Appeal NO: ~~ACP~~ ABP-322154-25Defer Re O/H ☐Having considered the contents of the submission dated/ received 24/11/25  
fromGraigie Ballylahan GAA Club I recommend that section 131 of the Planning and Development Act, 2000  
be/not be invoked at this stage for the following reason(s): No new planning issuesE.O.: Daniel O'ConnorDate: 25/11/25

Graigue Ballycallan GAA Club  
Tom Ryall Park  
Kilmanagh  
Co.Kilkenny  
R95VK63  
23rd November 2025

Case Number ACP-322154-25

Planning Authority Reference number: 2560003

Figure 18. Tullaroan Stream in Kilmanagh town longitudinal profile showing water levels in the river channel for Existing and Design River System for Q_{100cc} .

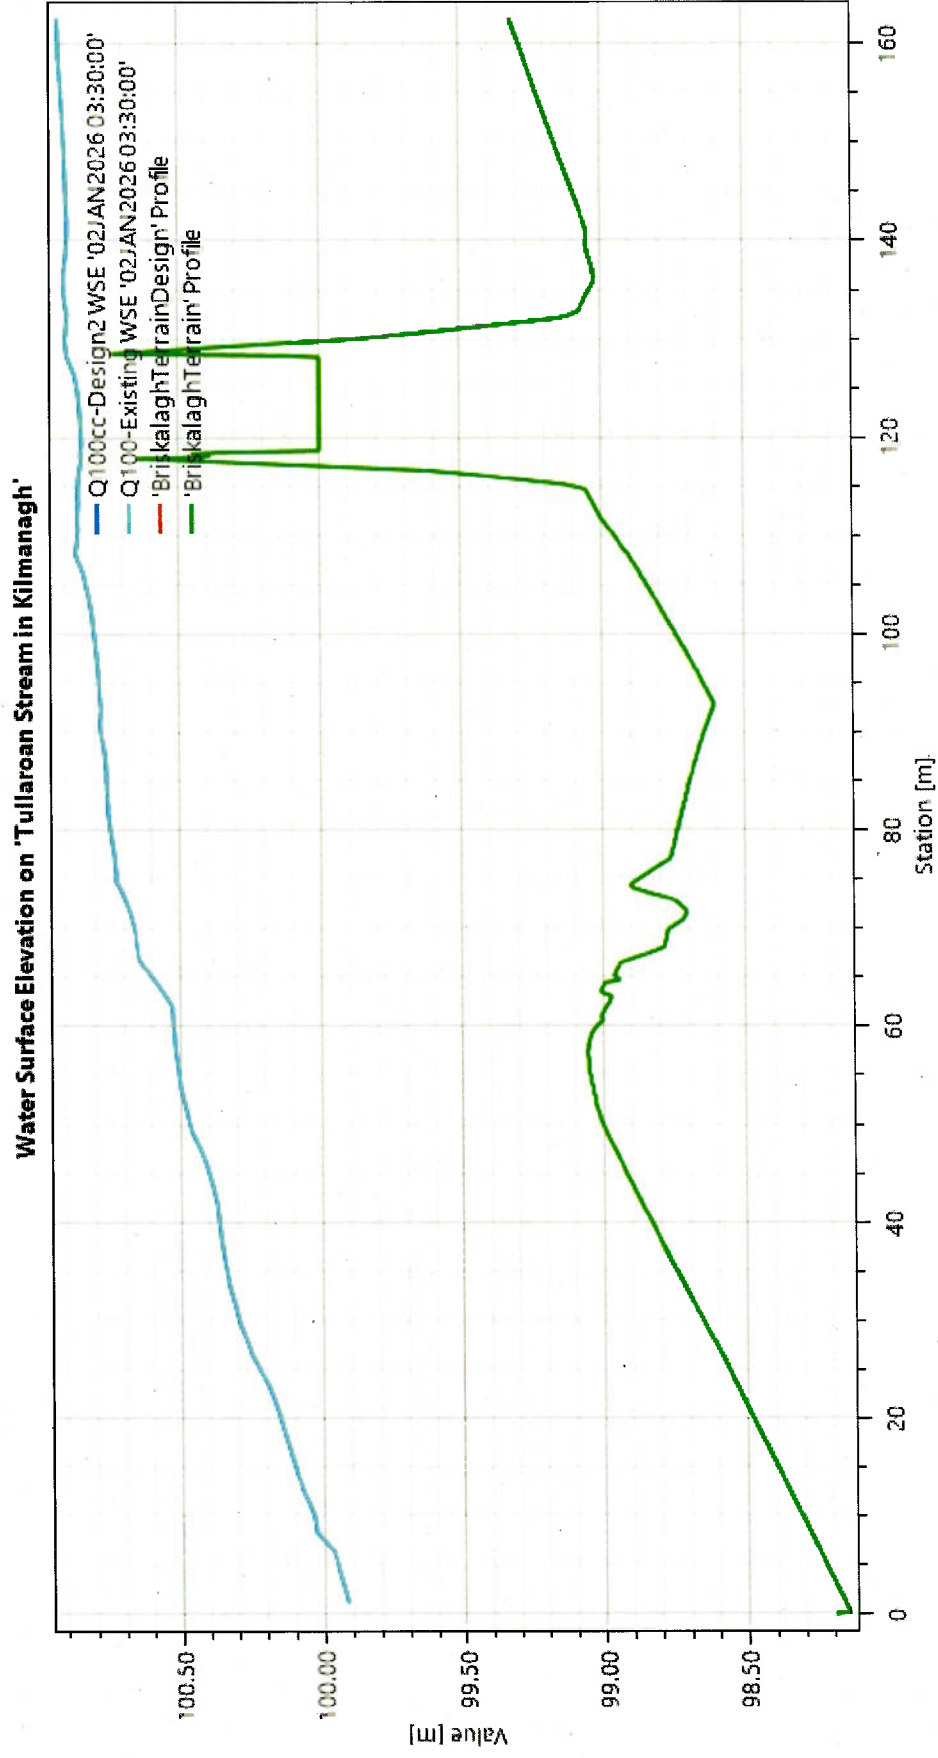
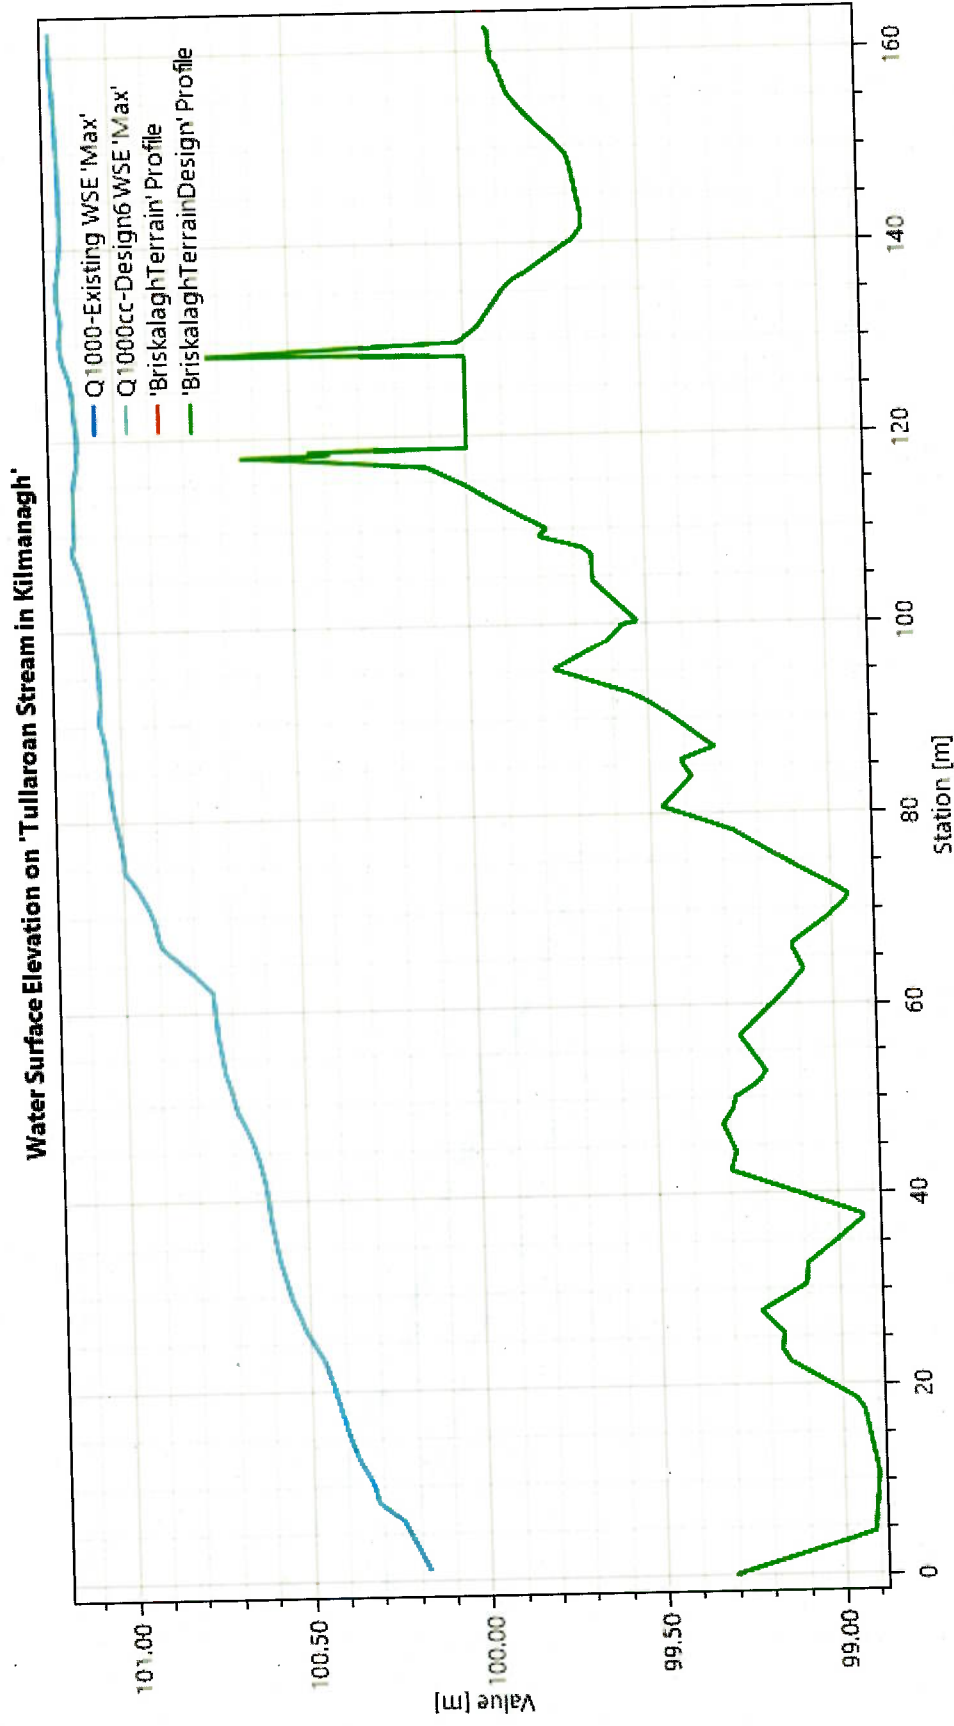
- Page 50 of the Fluvio R&D Limited report states that special attention was given to flood levels in Kilmanagh town. In particular, and as highlighted in Figures 33 & 34 of the report, it is explicitly stated that during the occurrence of a Q100cc (1 in 100 year + climate change) or a Q1000cc (1 in 1000 year + climate change) the output of the hydraulic modelling exercise demonstrates that **the hurling pitch immediately downstream of Kilmanagh bridge does not flood**. This is a significant and concerning erroneous statement and miscalculation.

- The hydraulic model used by Fluvio only extends for a distance of approximately **60m** downstream of Kilmanagh bridge. Our club grounds extend for approximately **500m** downstream from Kilmanagh bridge. In this regard the hydraulic model in no way represents the existing baseline scenario and proposed development scenario hydrological and flood regime at Kilmanagh. This is demonstrated by the point discussed above.

Figure 31. Kilmanagh town Tullaroan Stream longitudinal profile and two cross sections showing water levels in the river channel for Existing and Design River System for Q_{100cc} .

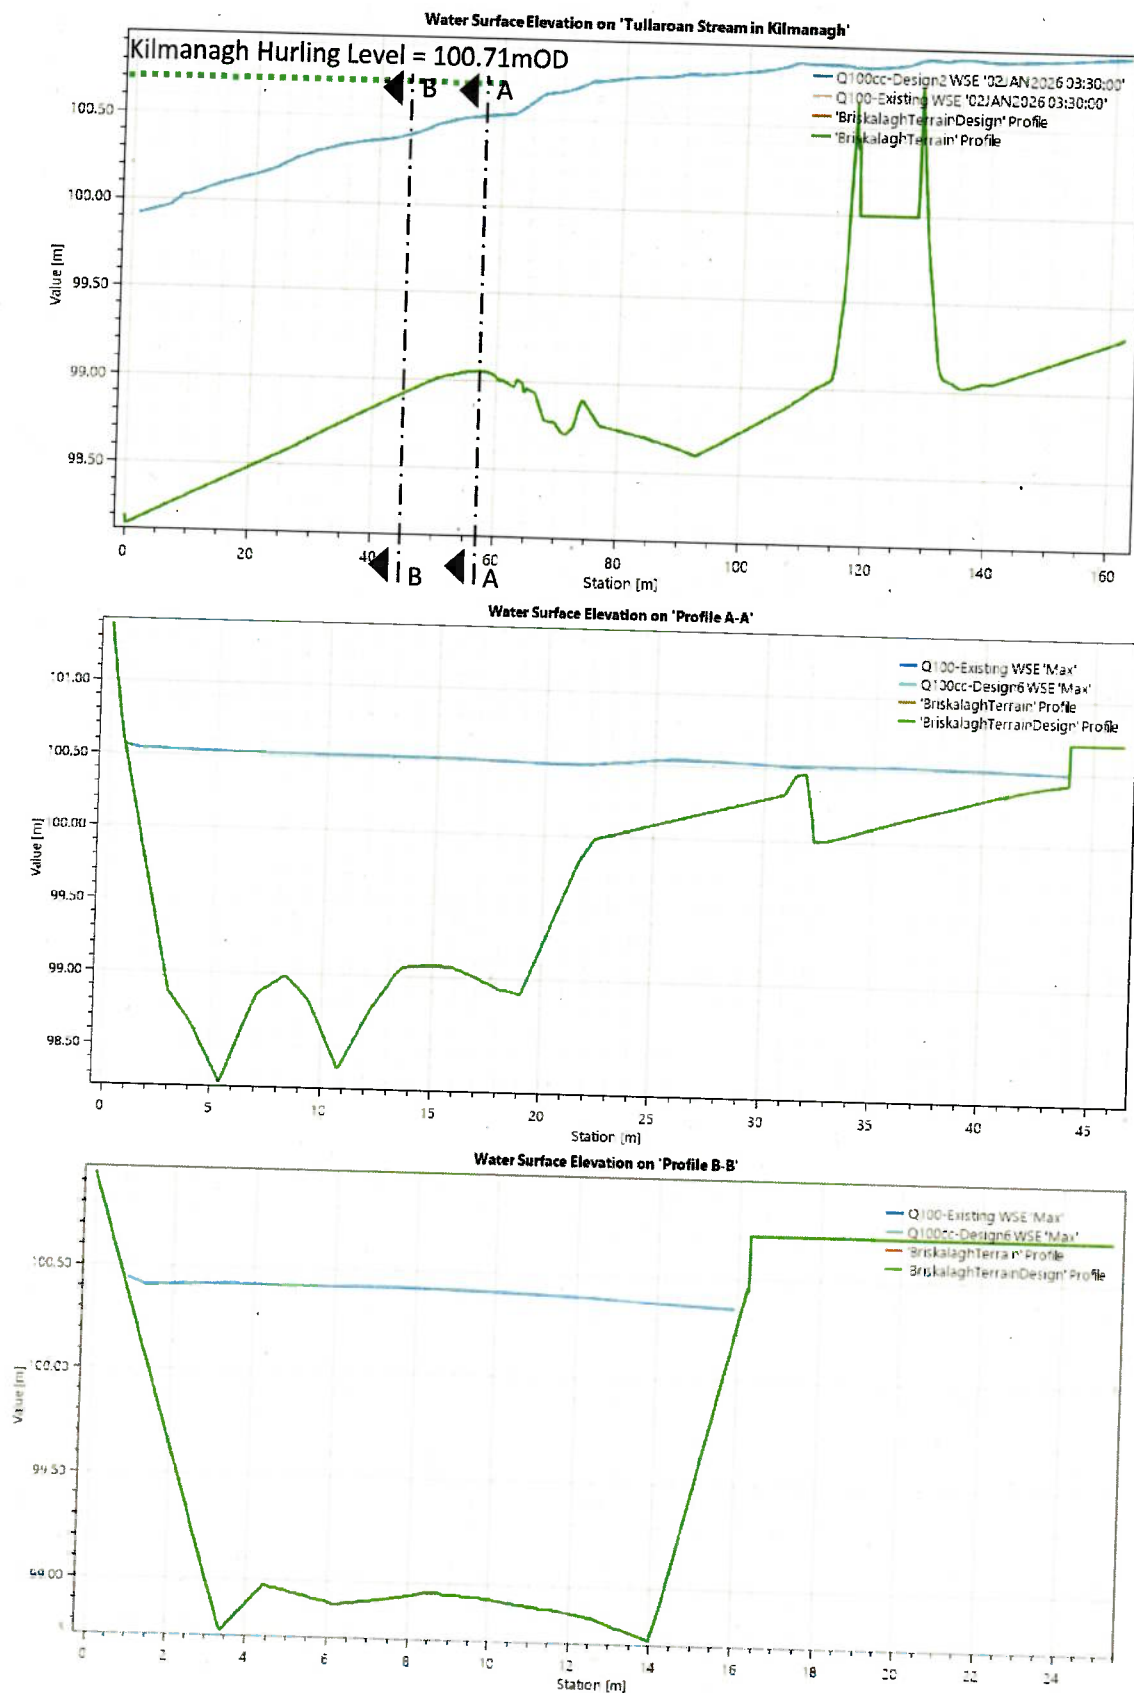
- The analysis concluded that:
- The hurling pitch, e.g. downstream right floodplain **does not flood** for Q100.. and Q1000..'
- To say that the hurling pitch(es) in Kilmanagh are only in danger of 1 in 100 year or 1 in 1000 year floods is simply erroneous as our original submission contained photographic evidence of extreme flooding of the hurling pitches in October 2022 and again in October 2023. As recently as the 11th November 2025 one of the pitches was flooded up to 304mm.

- This flood event had an estimated return period of 1 in 15 years to 1 in 20 years at this location, however the assessment and analysis undertaken by Fluvio R& D Limited presents that the hurling pitch would not be subject to flood inundation up to the 1 in 1000 year + climate change flood event. This demonstrates that this Site Specific Hydraulic Modelling exercise is significantly flawed and does not
